RE: *SEPA File No. SE-22-00002 (Cape)*
SEPA Comments on the Determination of Nonsignificance

This firm represents Jon Hoekstra and Jen Steele. Mr. Hoekstra and Ms. Steele own property and reside at 1101 Alice Road, Cle Elum, WA 98922 (Parcel No. 355834), located along Alice Road and immediately to the north of the proposed improved access road south of Alice Road. This letter sets forth supplemental comments on the Determination of Nonsignificance (DNS) issued by Kittitas County under SEPA File No. SE-22-00002 and associated grading permit application (GP-22-00009). These comments are provided pursuant to chapter 43.21C RCW, WAC 197-11-340 and WAC 197-11-500, *et. seq.*, and Kittitas County Code chapter 15.04, Art. V.

Parcel #19162 Driveway Improvement Extents

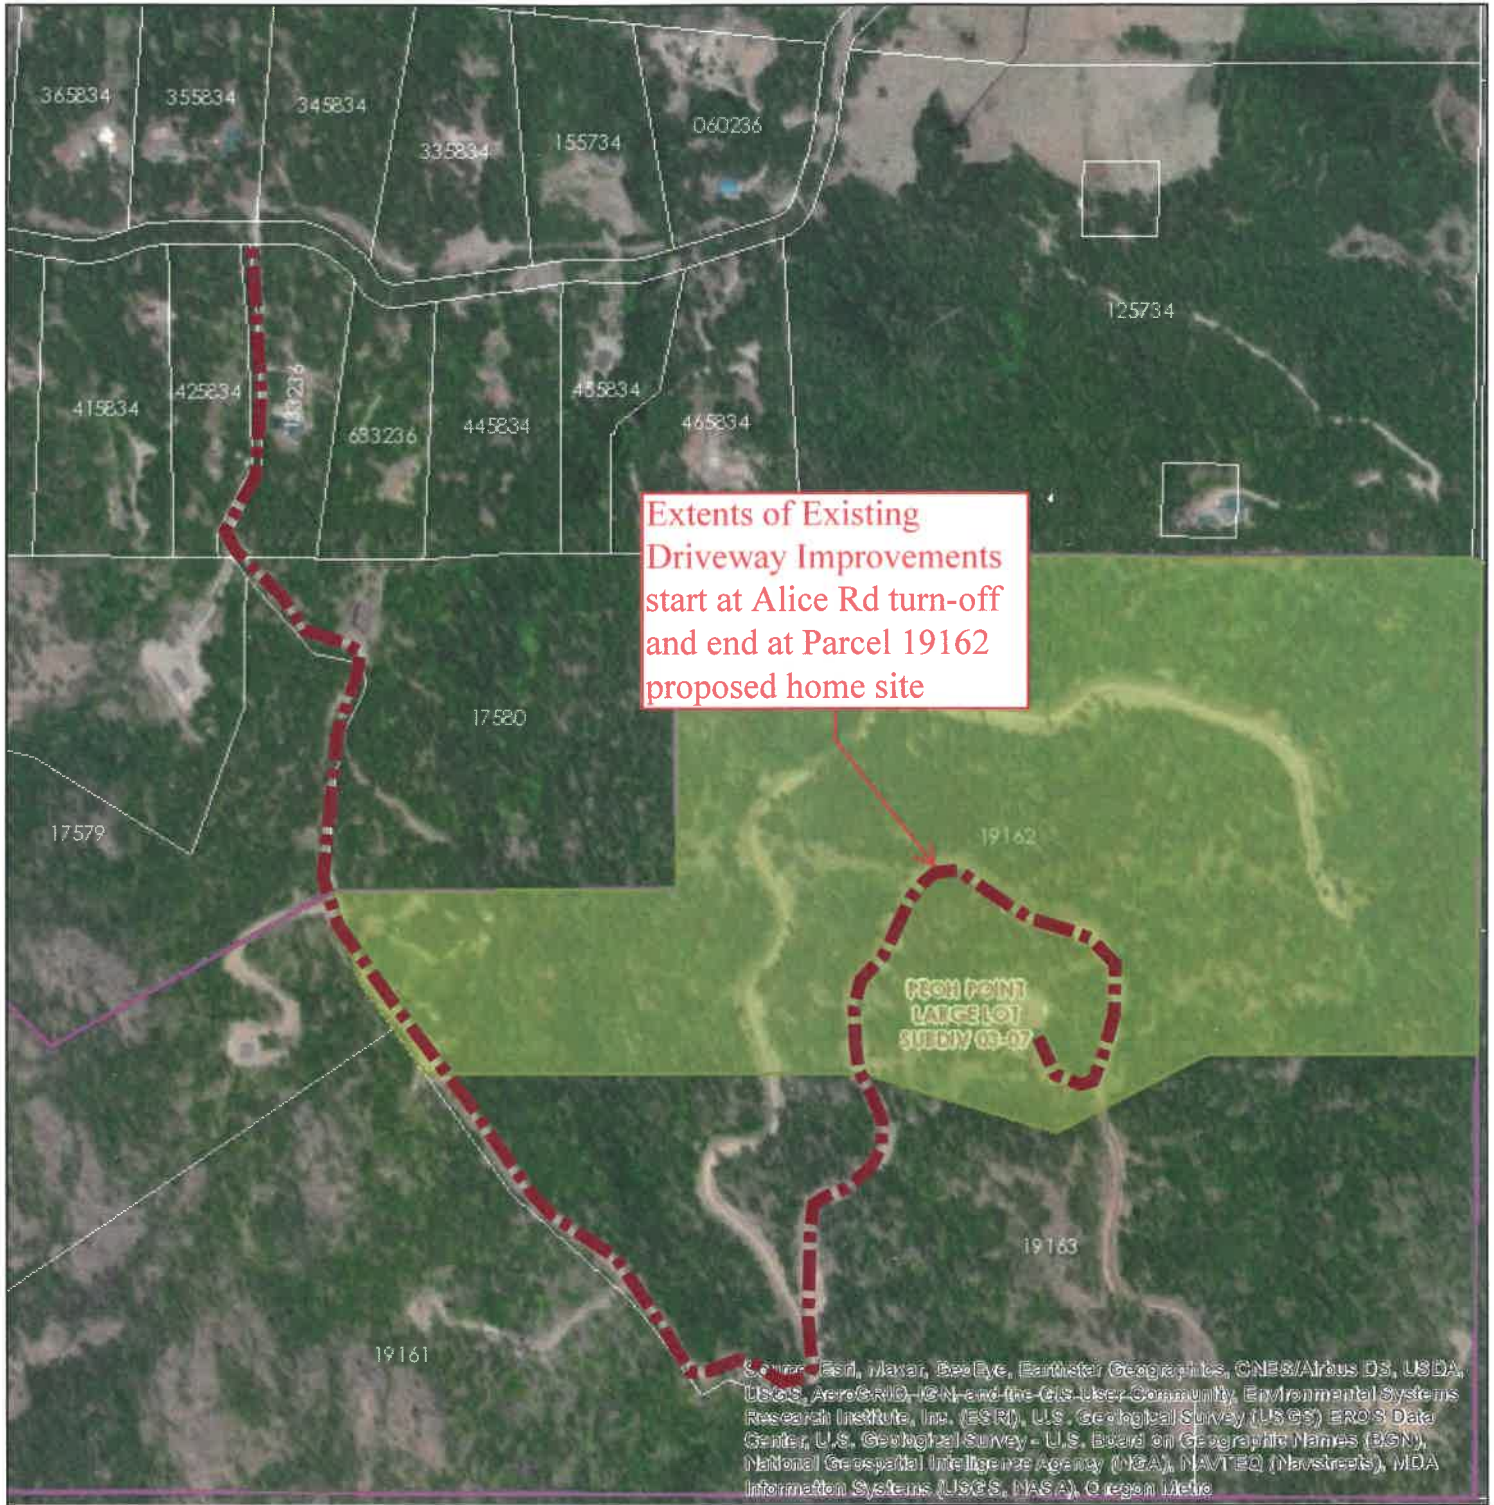
First, the County’s SEPA review did not properly consider application of appropriate Title 12 standards applicable to the project in reviewing the application as a “driveway” proposal.

Kittitas County Code is clear in denoting the proper classification of the subject “access road” as a “private road” and not a “driveway”. Kittitas County Code defines a “driveway” as being an “[a]ccess road used by no more than two privately maintained residential, commercial, agricultural or industrial properties.” KCC 12.02.020(T) (emphasis added). In contrast, the Code defines a “private road” as “[a]n access road serving three or more lots, residences or multi-family units that is privately owned and maintained for the use of the owner(s) or those having expressed or implied permission from the owner(s).” KCC 12.02.020(AI) (emphasis added). Comments submitted by Mr. Hoekstra and Ms. Steele show that the proposed access road serves nine properties or lots, at least five of which are already developed with residential structures.¹ In fact, while undercounting the actual lots and developed residences, the applicant’s own application materials also note the existence of existing residences and properties accessing the subject access road.² Accordingly, under County Code provisions, the access road proposed for improvements is properly characterized as a “private road” and not a “driveway” for purposes of the County review and Code application.

Based on the above, the application materials’ reliance on Table 4-4B (Driveway Design Standards) is erroneous.³ Table 4-4B is applicable only to single and joint-use “driveway[s].” Rather, Table 4-4A (Private Road Minimum Design Standards) provides the applicable required standards for this project. Further, as the subject access “private road” serves at least nine separate “lots” (and,

upon completion of the applicant's project would serve at least six residences or improved properties), the standards in Table 4-4A applicable to a "private road" serving 3-14 parcels and/or units need to be evaluated and satisfied.

As neither the SEPA checklist nor the application materials identify the appropriate standards, it is evident that the County's review was based on either insufficient or incorrect information. The County's roadway standards, as codified in chapter 12.01 KCC, are specifically designed with general safety considerations in mind and to ensure proper safety, drainage, maintenance, and related considerations. See KCC 12.01.010; see also KCC 12.01.070(A) (Noting Title 12 KCC provisions "shall be regarded as the minimum requirements for the protection of the public health, safety, and welfare of the residents of Kittitas County") (emphasis added). These are all relevant SEPA considerations that should be properly identified and evaluated as part of the County's threshold determination process.⁴

Second, related to the above, the proposed access road is across property on steep slopes in excess of 15% (and as part of a larger site with slopes in excess of 25%). Steep slopes in excess of 15% are located near the intersection with Alice Road and present safety, erosion, and drainage concerns that necessitate careful evaluation under both the Title 12 standards and SEPA. These acknowledged steep slopes exceed the maximum grade allowable under Title 12 (Table 4-4A).

In addition to the general concerns outlined above, the steep slopes and grade associated with the proposed improvements raise issues that do not appear to have been identified or evaluated with respect to fire and emergency access. Steep terrain (here in excess of permitted County standards) is often inaccessible to emergency vehicles and fire response apparatus. Further, as Public Works has commented, Alice Road would need to be certified up to the point of an approved fire apparatus turnaround. Lacking from the SEPA checklist or documents reviewed is any identification or evaluation of how the proposal will meet the minimum access requirements of the International Fire Code as adopted by the County, see KCC 12.04.070(A), where an approved

fire apparatus turnaround exists or is being proposed, see KCC 12.01.095(E), or other related and associated emergency access and public safety considerations.
